Recommendation Report for Approval of Reserved Matters Following Outline Approval

REF NO: LU/121/17/RES

LOCATION: Land North of Toddington Lane
Parcel C1 & part Parcels B2, B4 & C2
Littlehampton
BN17 7PP

PROPOSAL: Approval of reserved matters following outline consent LU/47/11/ for construction of 126 No. dwellings together with internal road network, car parking & landscaping.

Tree planting into Granite Setts on Main Avenue - Plan
Scale 1:50

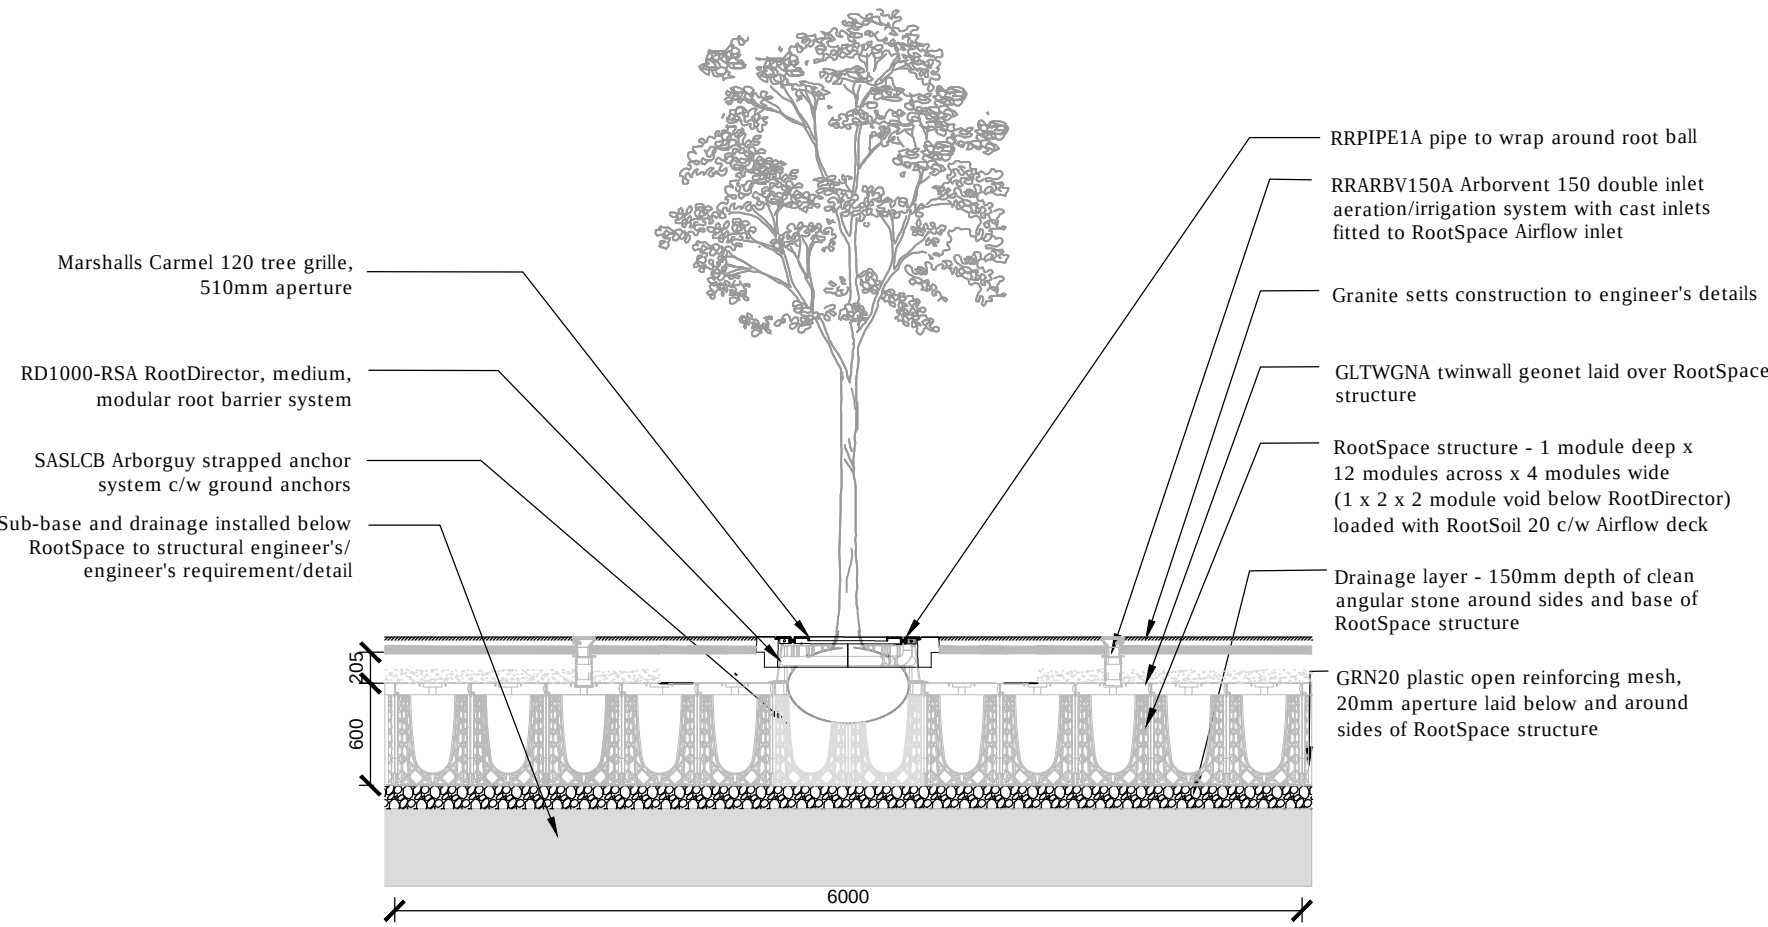
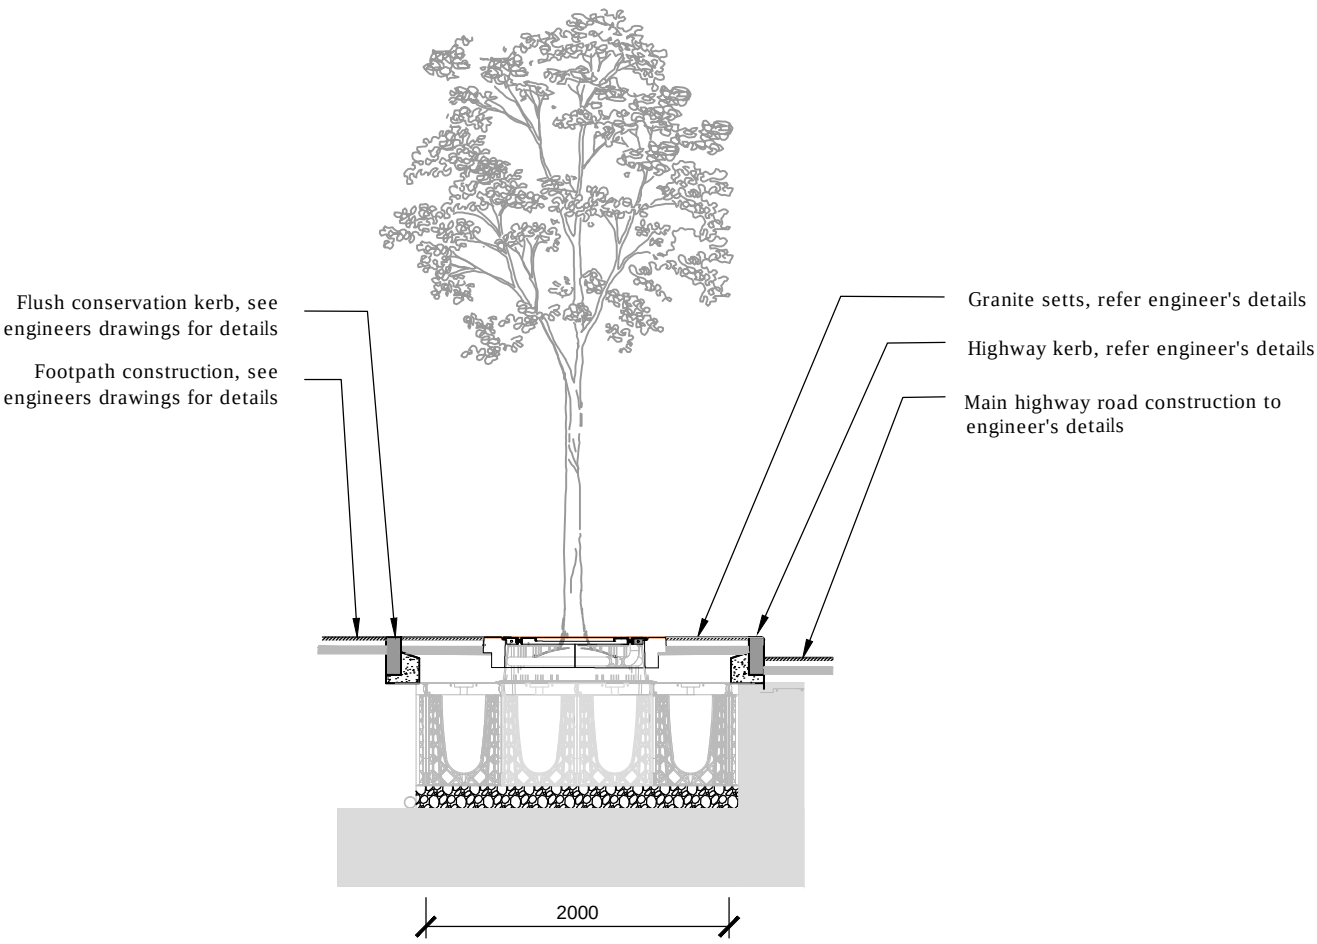
- (2) Landscaping - a continuous verge south of Main Avenue would not be appropriate adjacent to a retail/commercial element. With regard to hard landscaping (granite setts with trees pits adjacent are shown for parts of the main spine road leading into the development), this type of treatment should be removed and replaced with grass. Granite setts are potentially a safety hazard if pedestrians choose to cross over them, a maintenance liability and can create issues with tree growth adjacent.
